DOC20/935057

Senders ref: SSD 10382 (City of Sydney)

Subject: Notice of Exhibition – Student Accommodation, at 90-102 Regent Street, Redfern (SSD 10382)

27.000

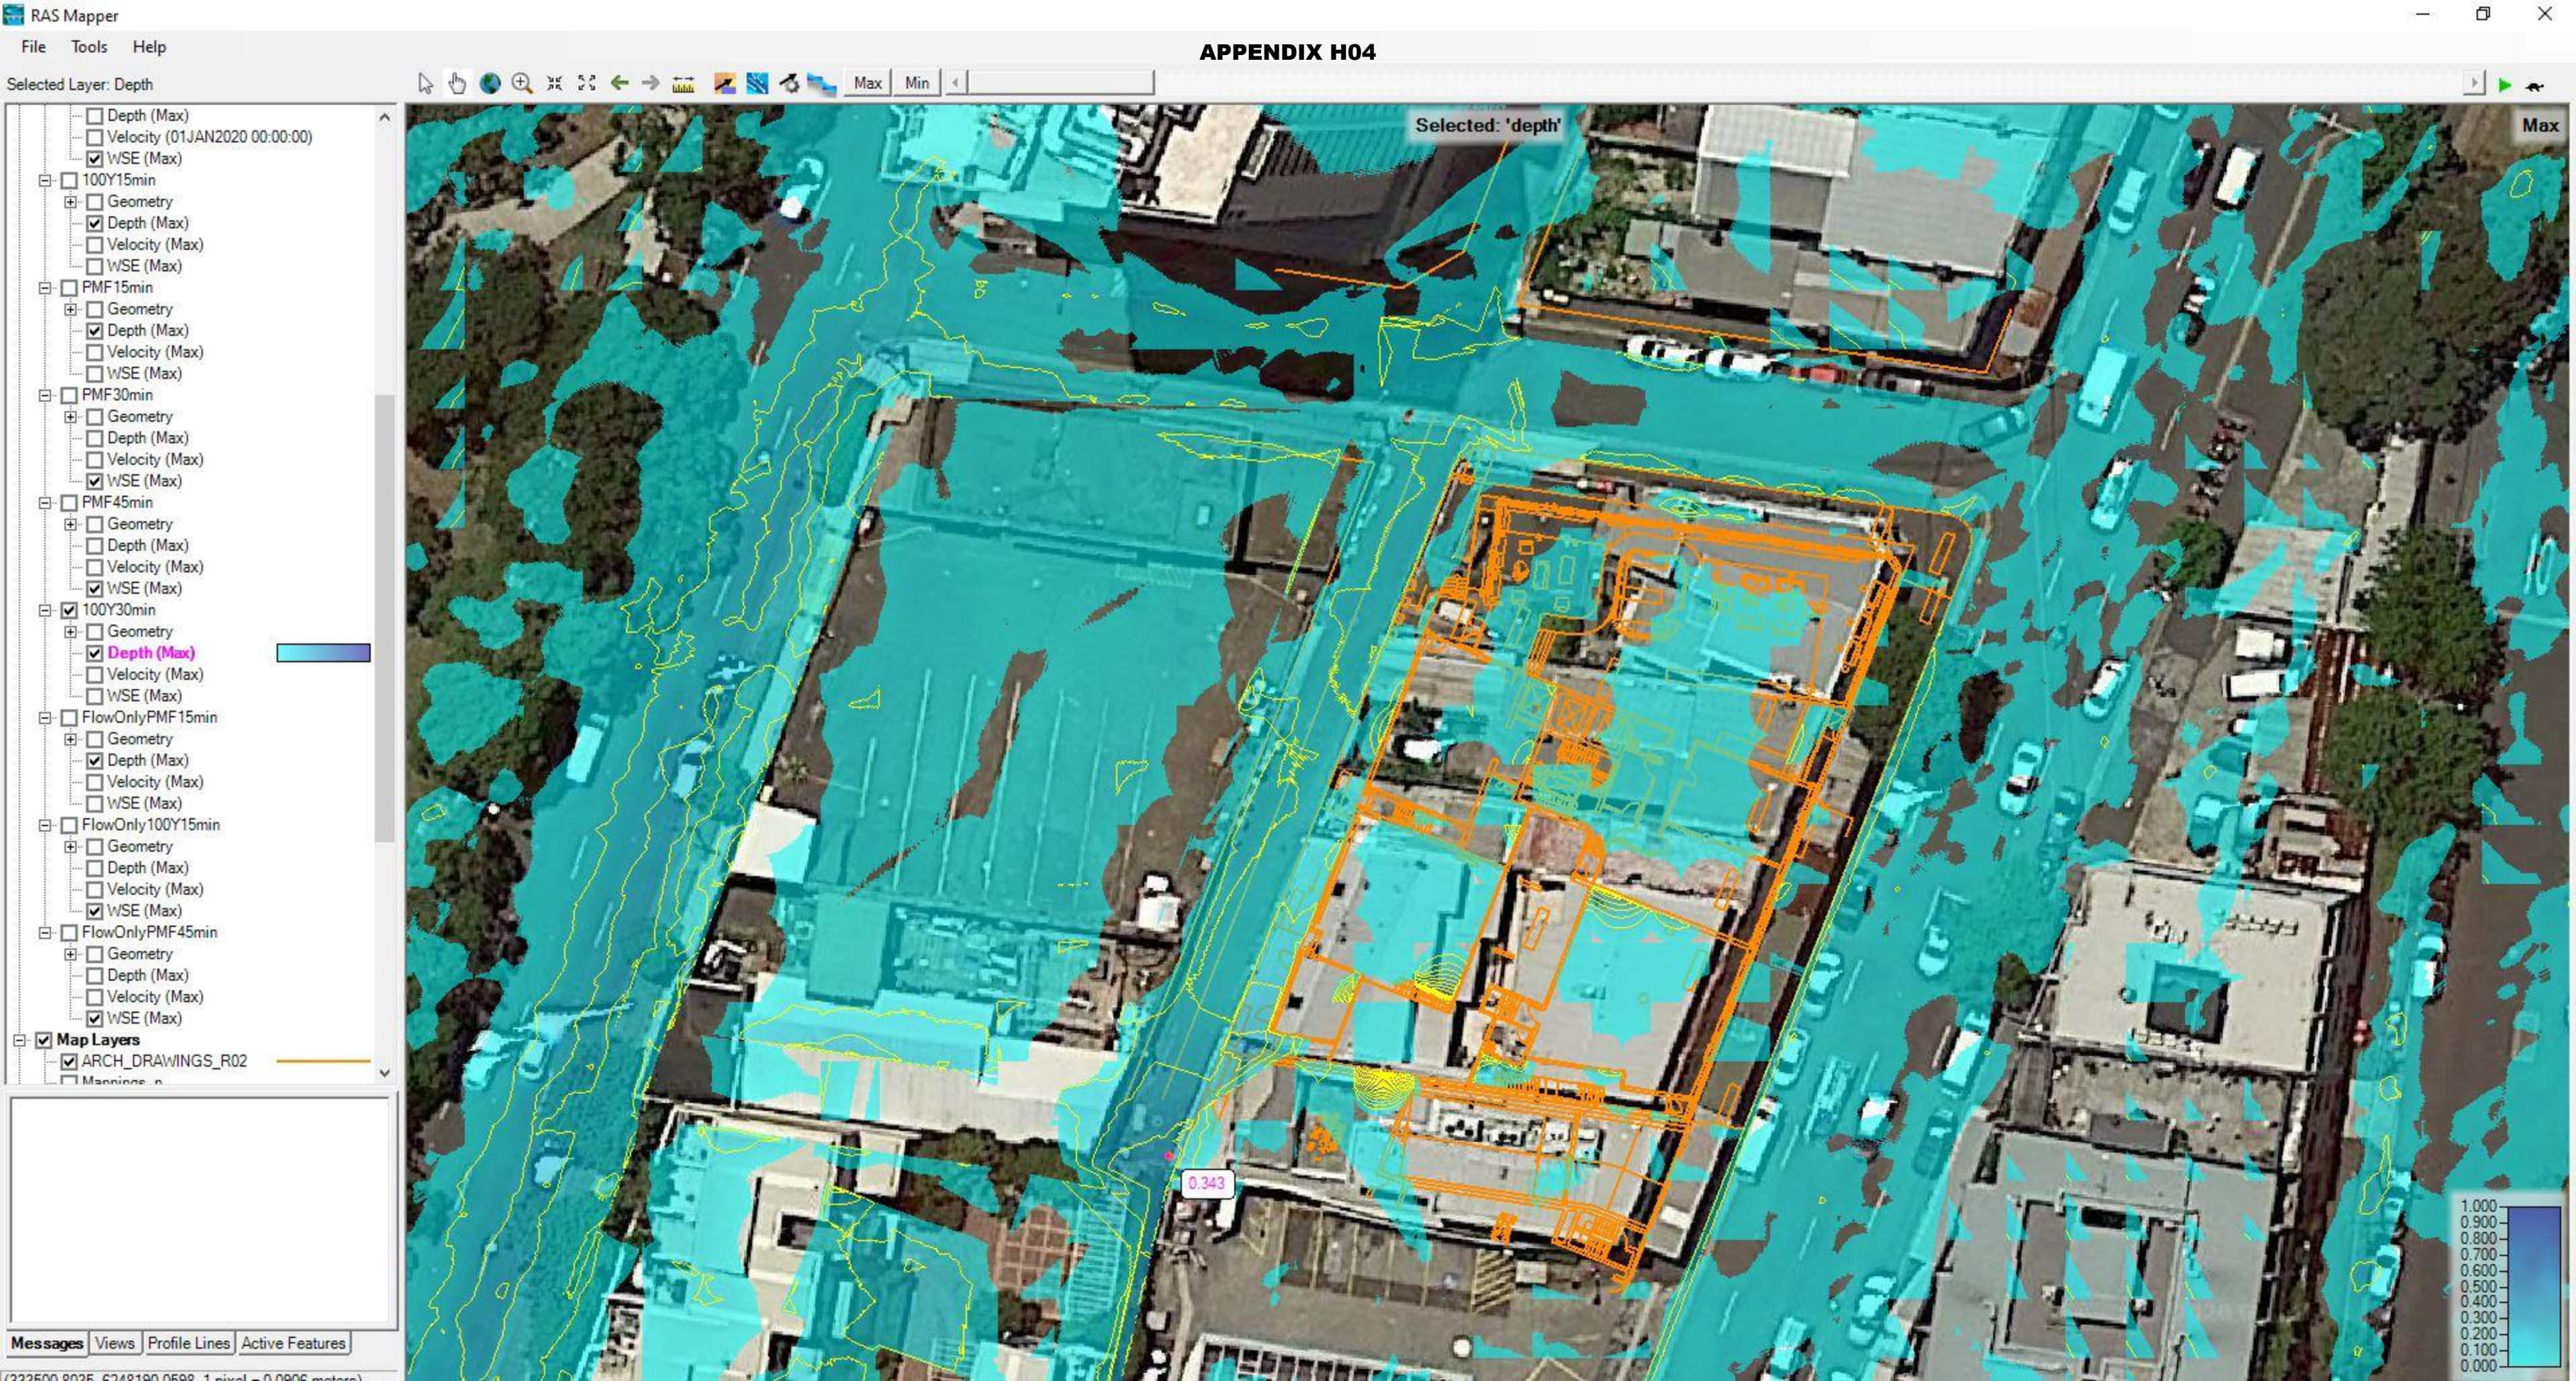
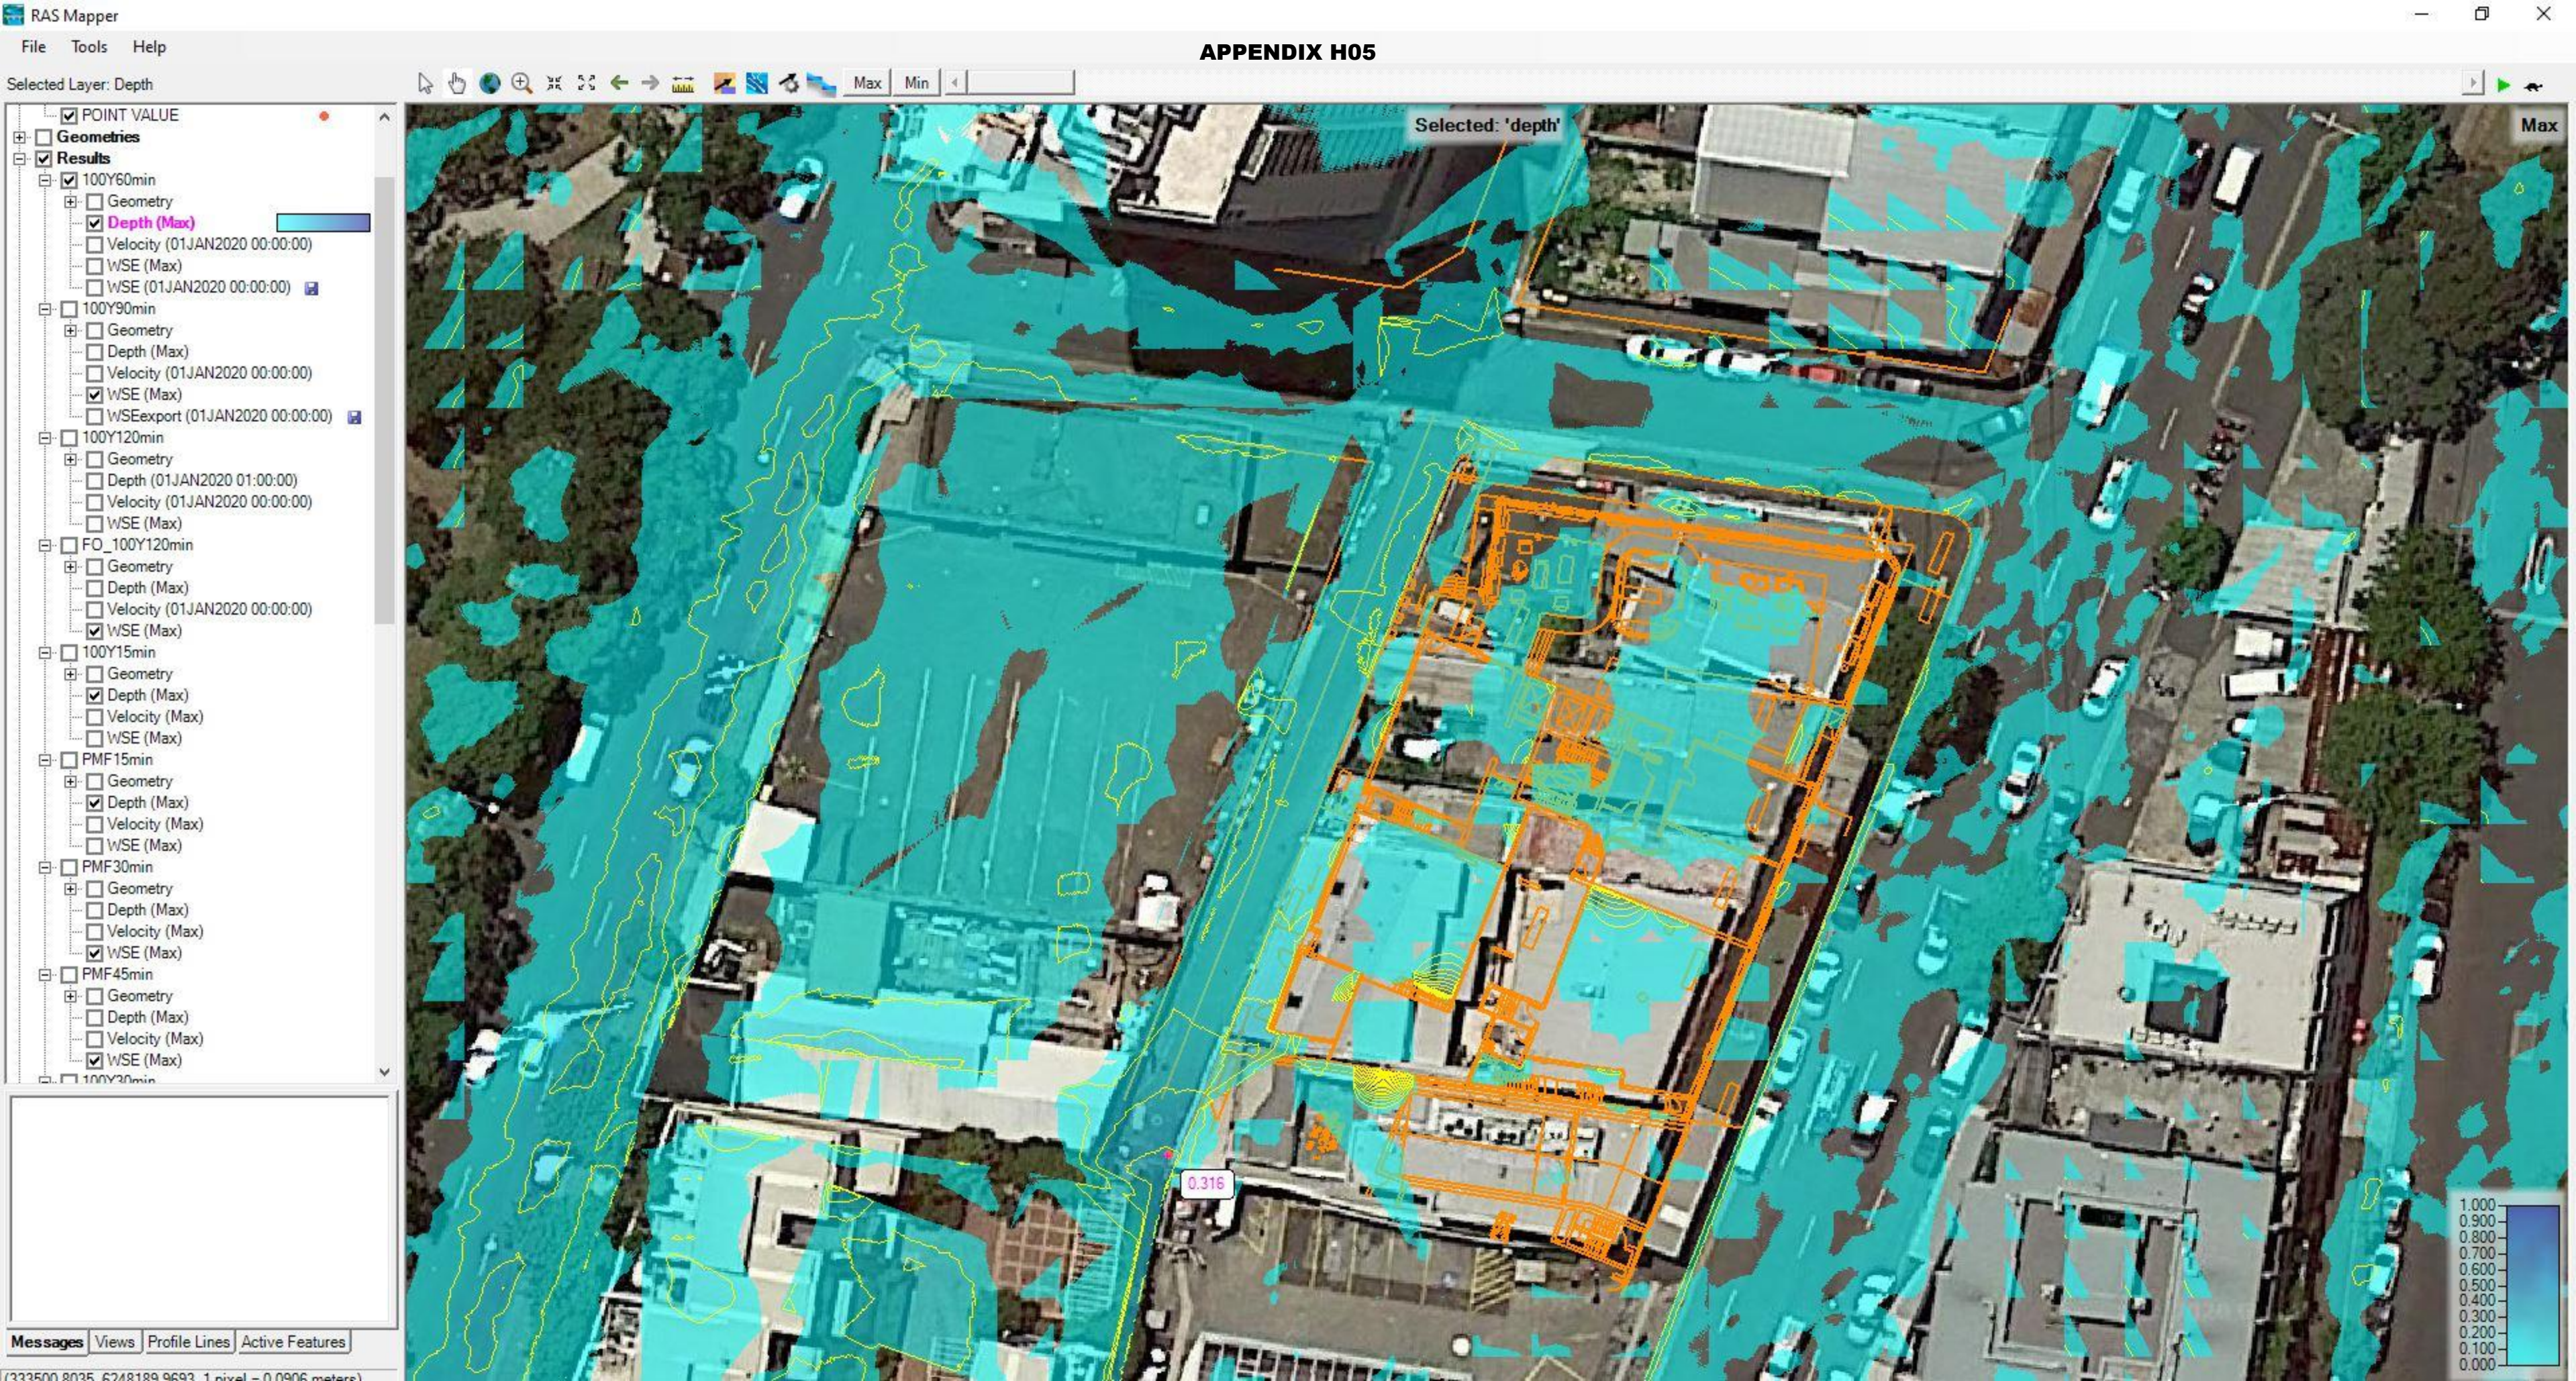
Flood planning levels have been provided, but it is unclear whether these are based on pre or post development modelling. Clarification is required. As stated above, the post development flood information cannot be used at this point. The proposed building includes a basement for bicycle storage, which requires all entry points to be above the 1% AEP flood level plus 500 mm freeboard and the PMF level. The PMF levels have not been calculated and are required for this assessment. EES notes that this requirement has not been met.
